# CITY OF ALBUQUERQUE

**Re: Via Electric, 2211 Candelaria NE.**  
**Grading and Drainage Plan**  
**Engineer's Stamp dated 11-01-13 (H16/D146)**

GRADING AND DRAINAGE PLAN

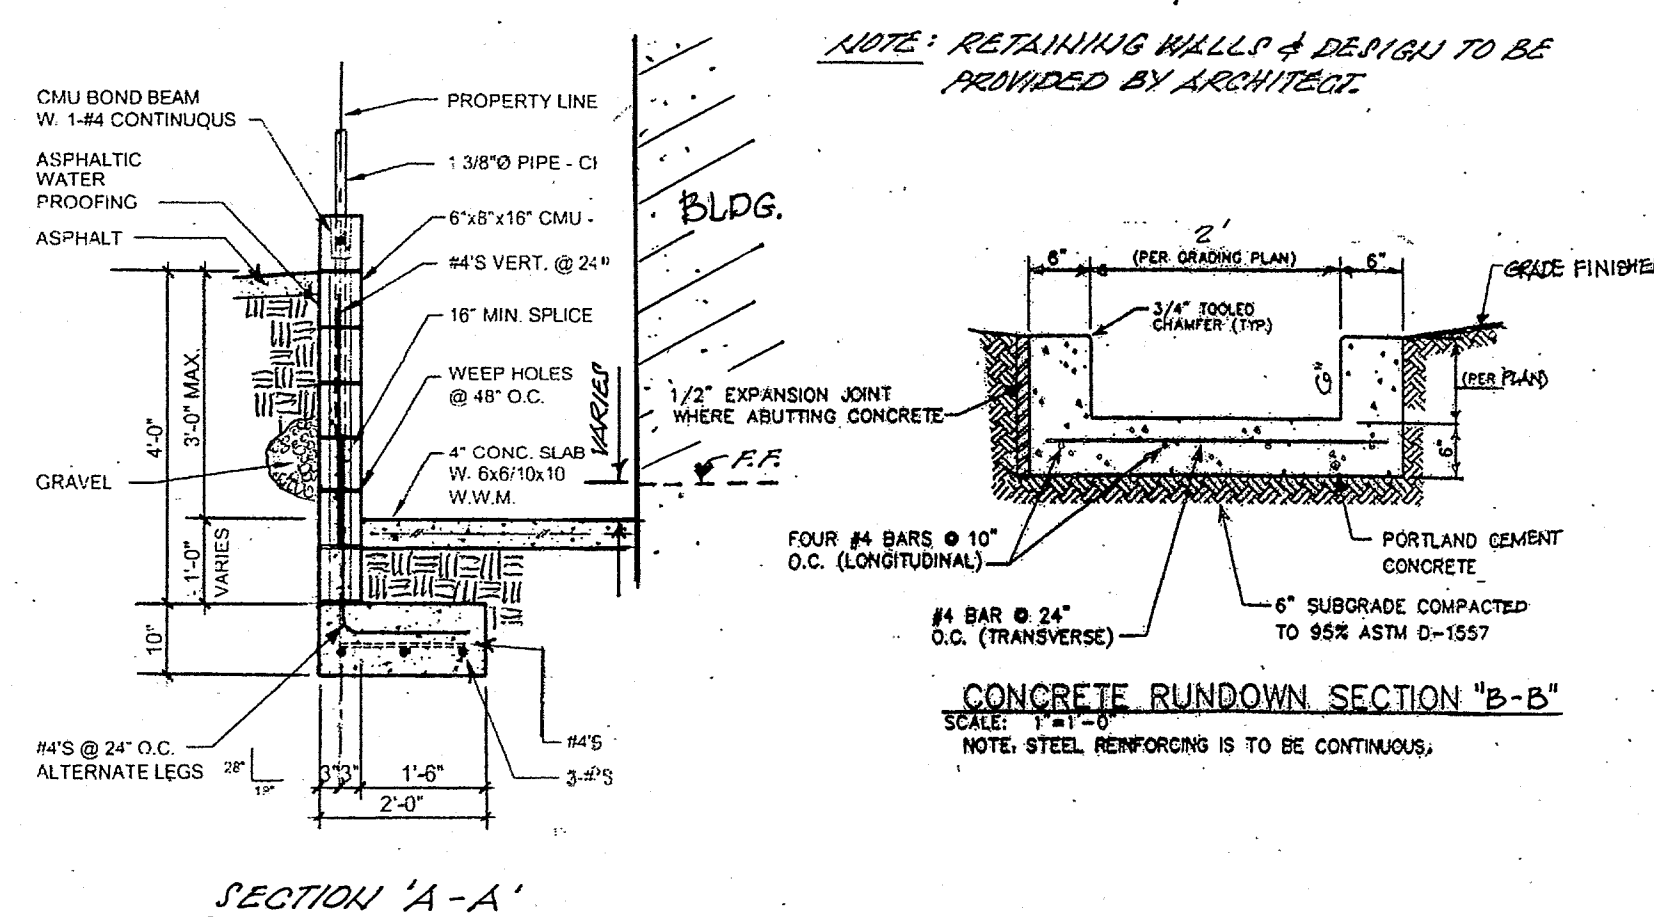
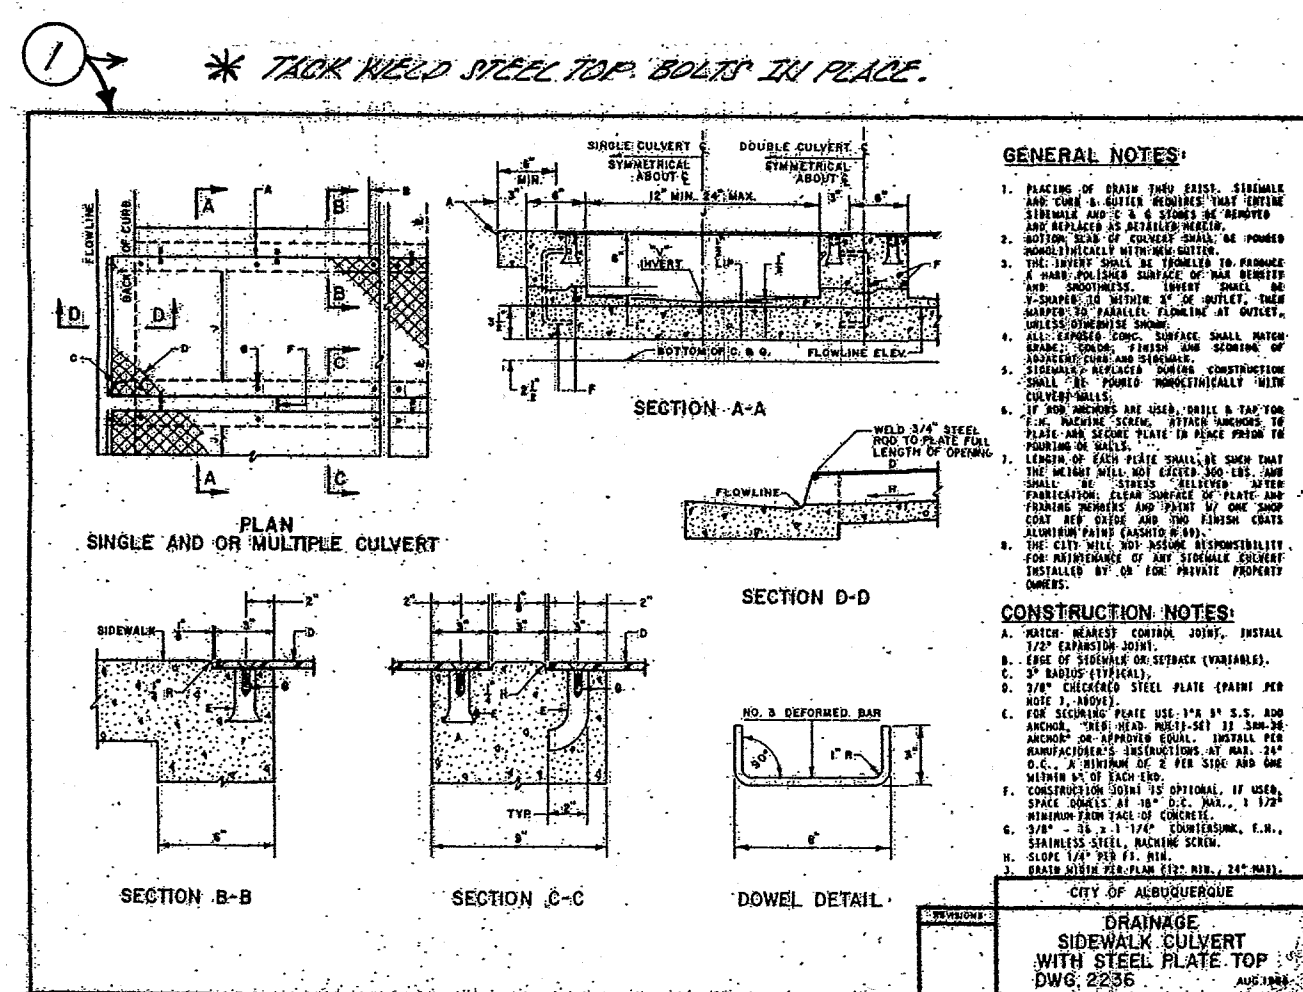
- A cross lot drainage agreement is needed.
- Flow points are needed for both swales.
- A basin map is required.
- Number 2 easement grading plan is not the correct scale.
